MEMORANDUM

TO: Jean Fraser, Planner
FROM: David Senus, P.E.
DATE: August 27, 2013
RE: 133 York Street – 6 Unit Residential Building, Level III Site Plan

Woodard & Curran has reviewed the Level III Site Plan Application for the proposed 6 unit residential building located at 133 York Street in Portland, Maine. The project consists of replacing an existing 2 unit building with a 6 unit building, along with associated site improvements, landscaping, and utility connections. The project will result in a net increase in impervious area of 3,652 SF.

10 TREE FILTER DETAILS

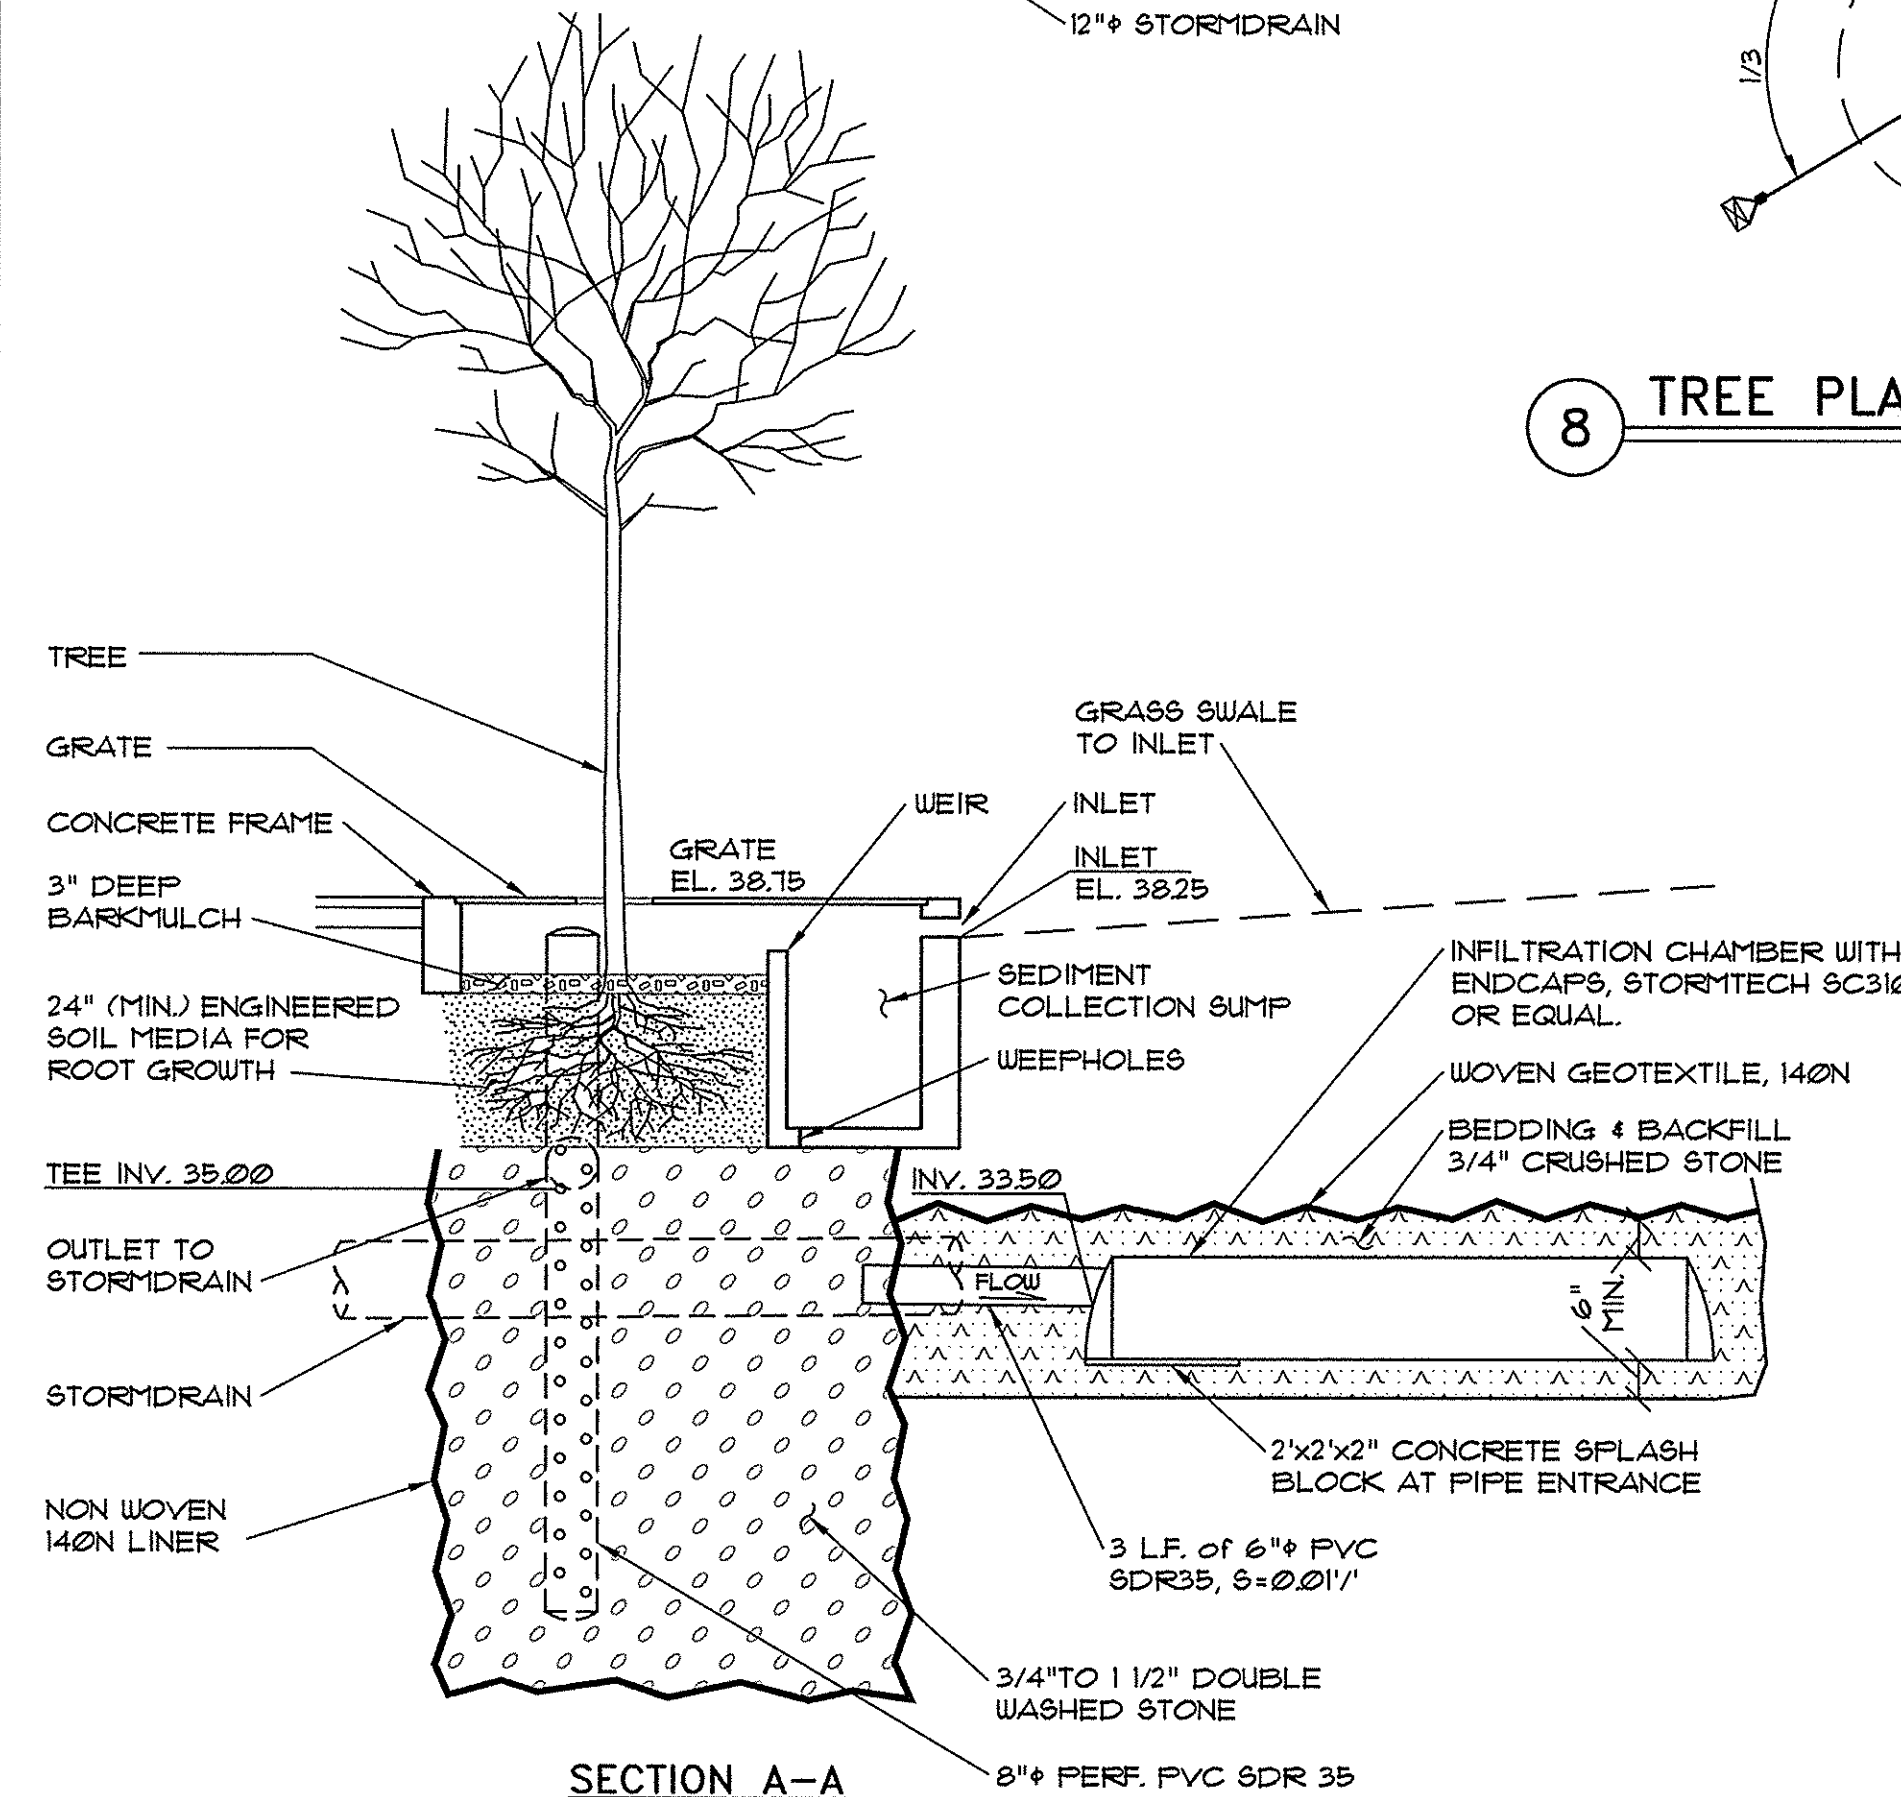
- b) General Standard: The Applicant has proposed a stormwater tree well to treat runoff from an impervious area in excess of the proposed new impervious area; the approach meets the intent of the General Standards. The Applicant should provide calculations on the sizing and design of the tree filter system, and clarify the system dimensions on Tree Filter detail sheet.

- 4) Provide additional information related to the roof drain connection to the treewell filter and the treewell filter connection to the site's storm drain system (provide pipe sizes, invert elevations, and detail the connections to the tree filter).

C1.1

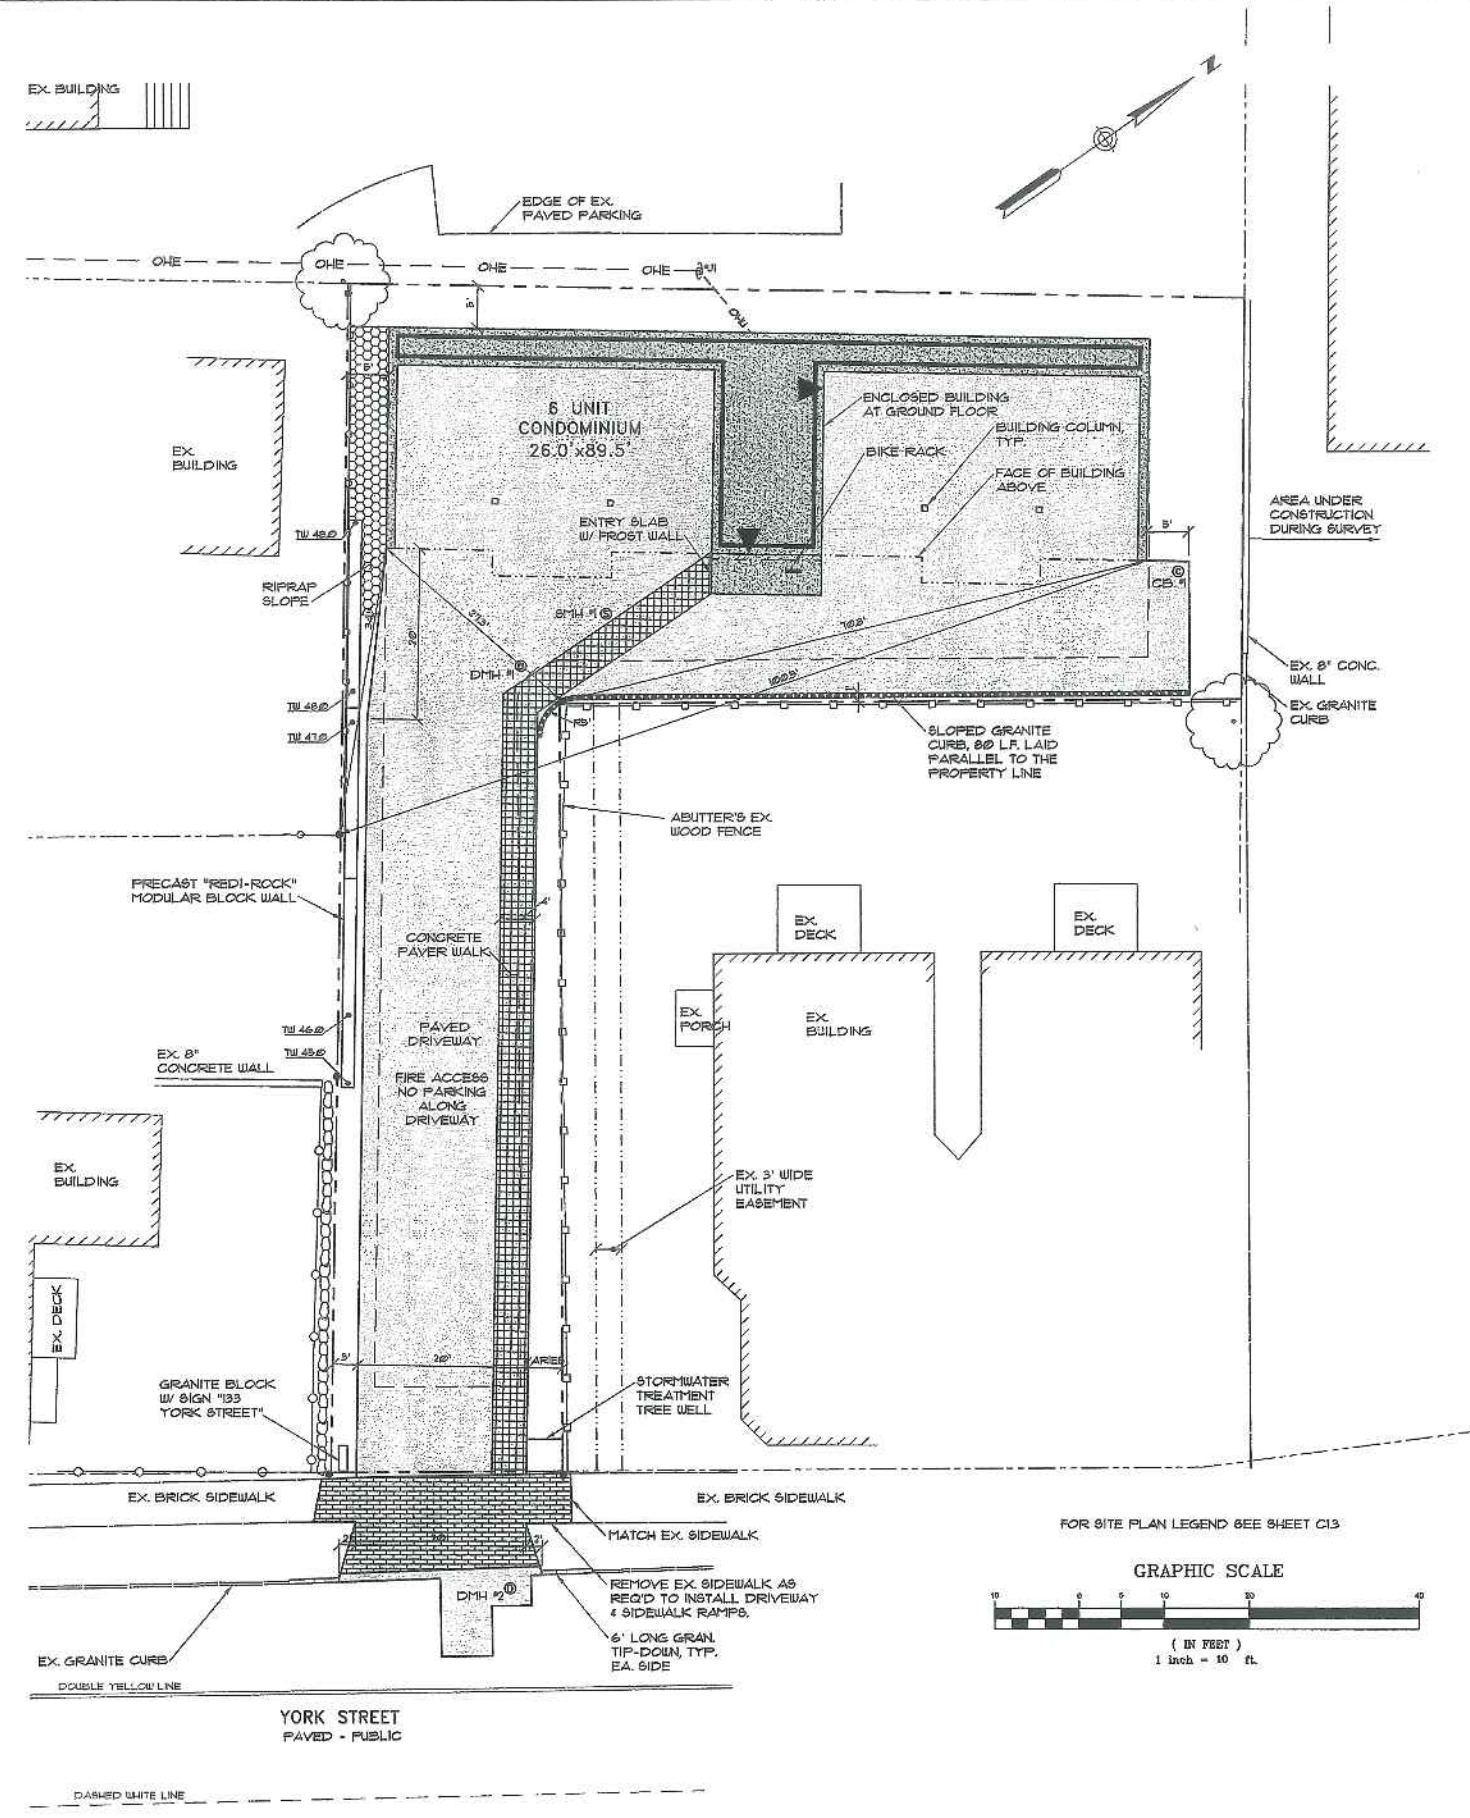
- 6) Note 3 on C1.1 states that "All Powerline Utilities Shall Be Overhead"; however, a note on C1.3 indicates an underground connection from the utility pole at the rear of the building; please clarify. In addition, it appears that an easement will be required from McCormick Place Condominium for this underground utility connection.

C1.3

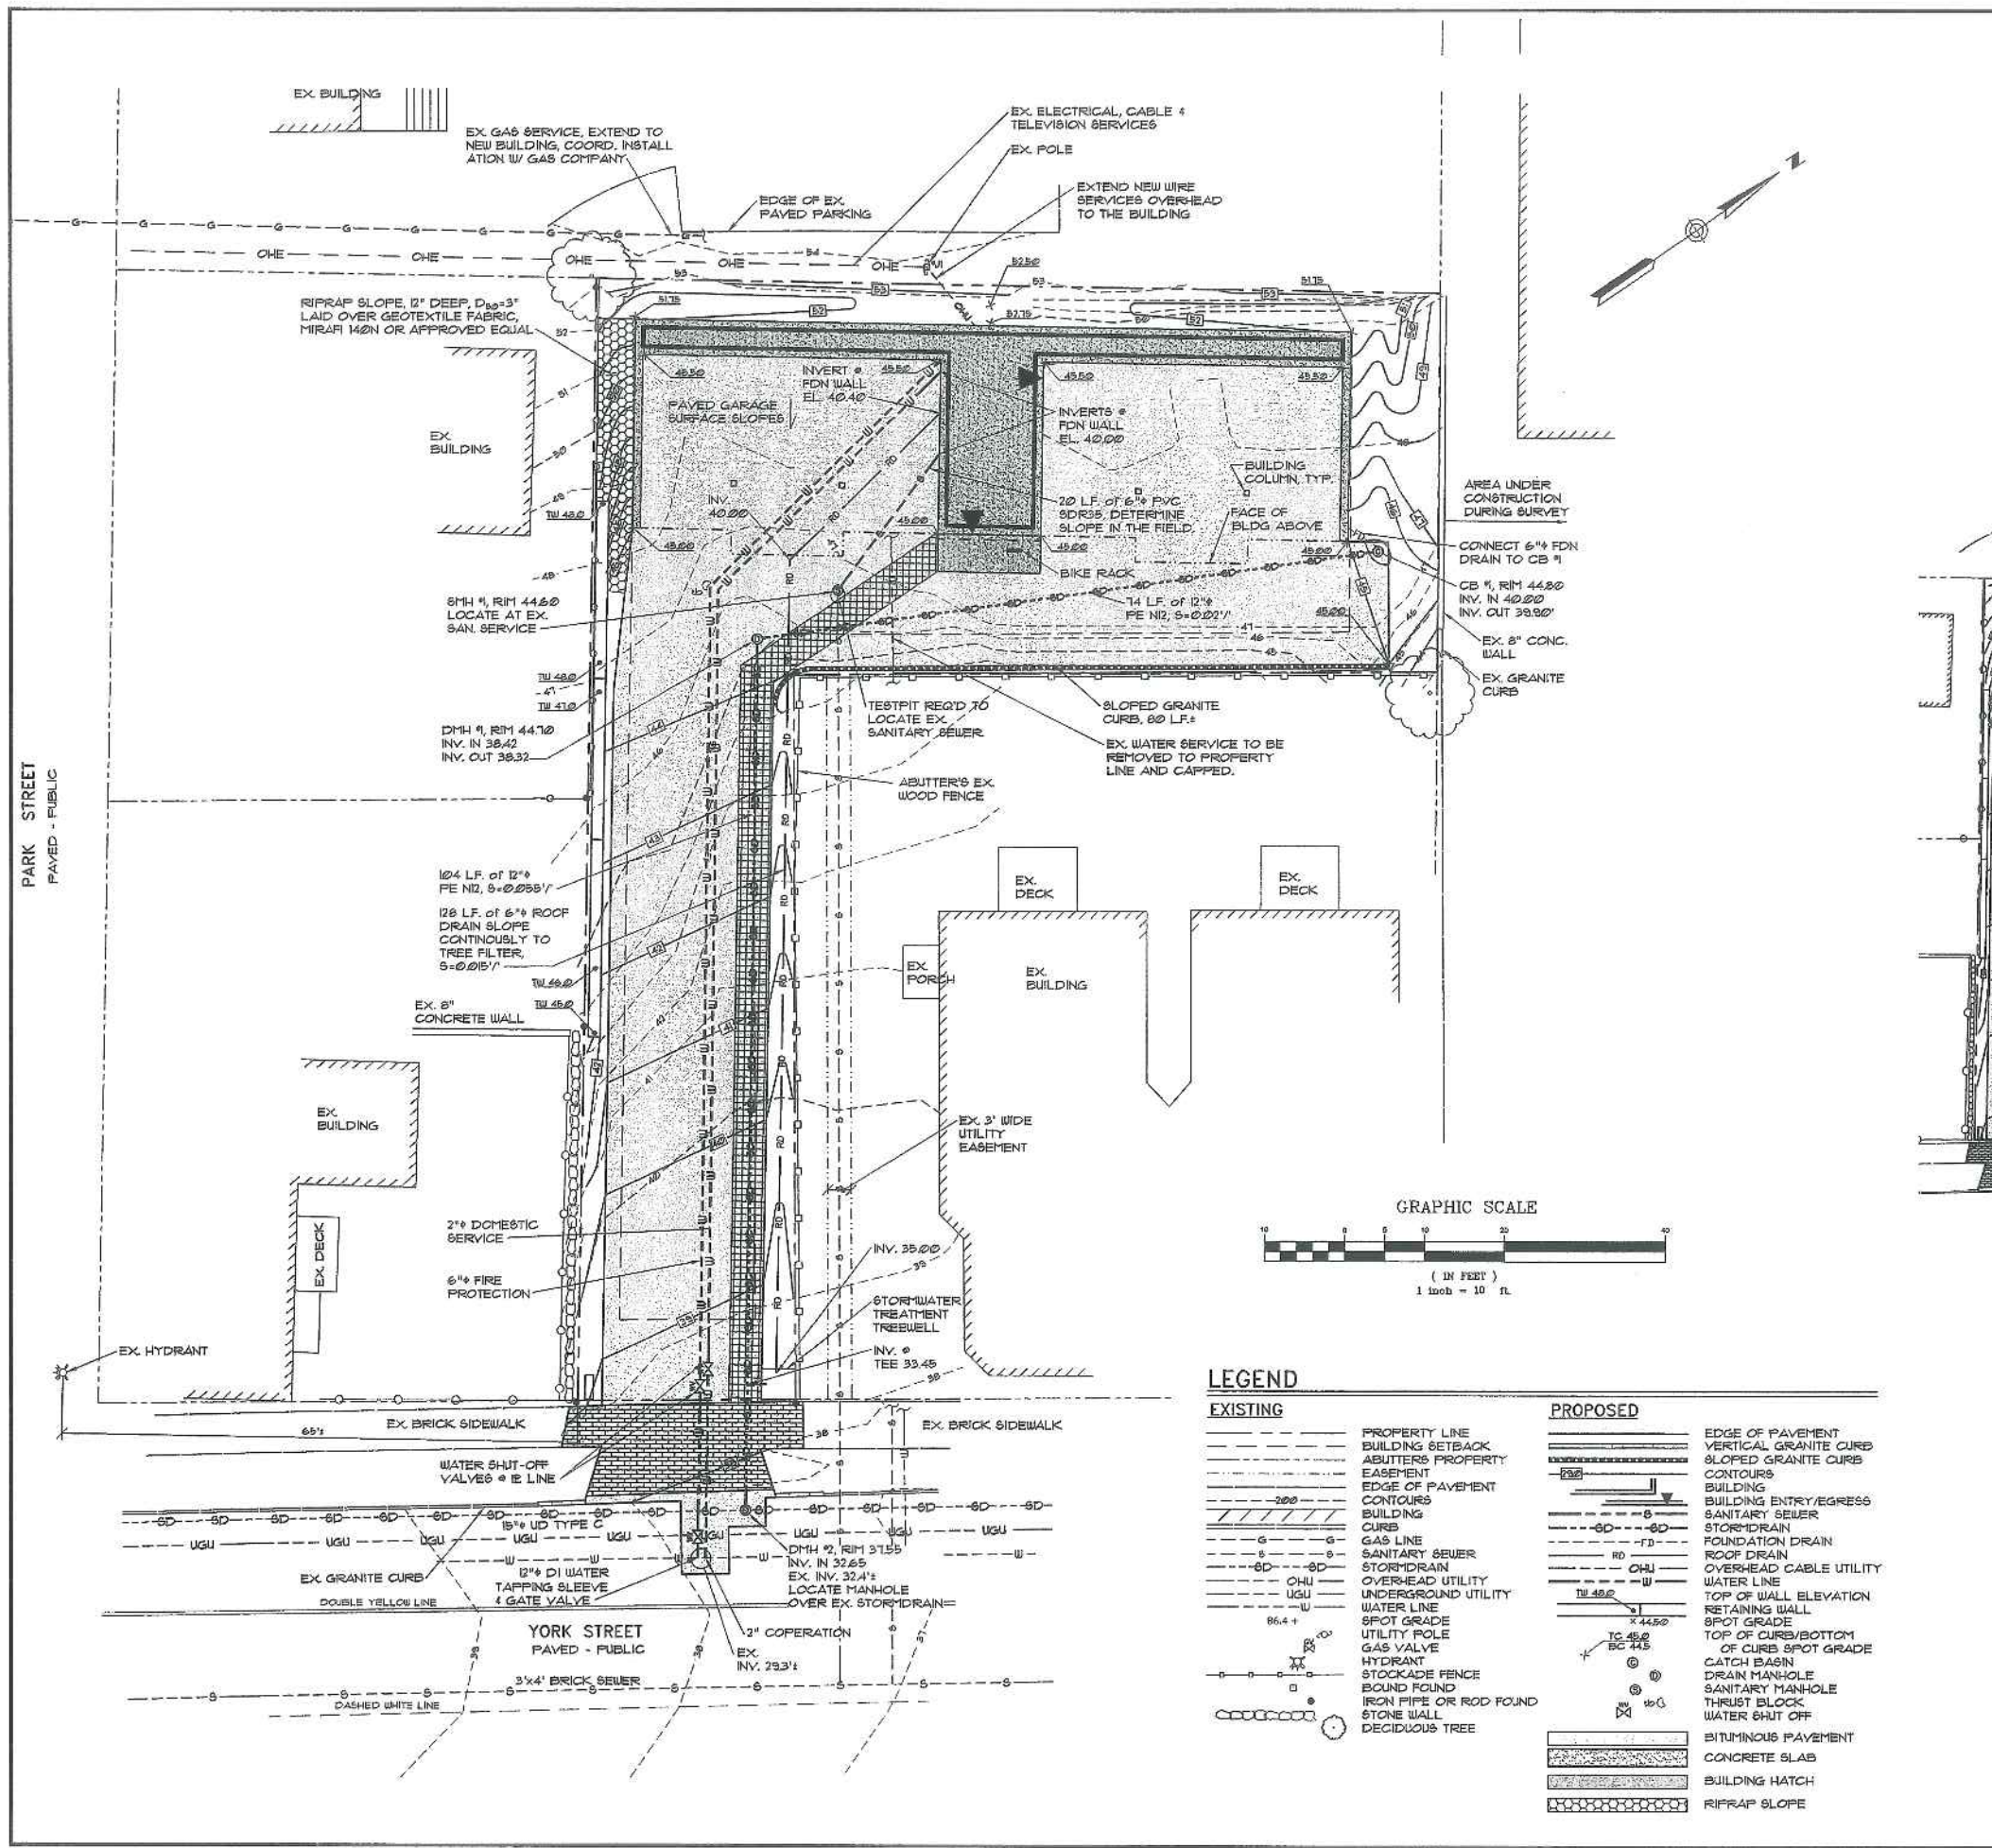
- 5) Proposed topography on C1.3 indicates that a portion of the drainage from uphill lots will be routed directly along the west building wall, please review the grading in this area.
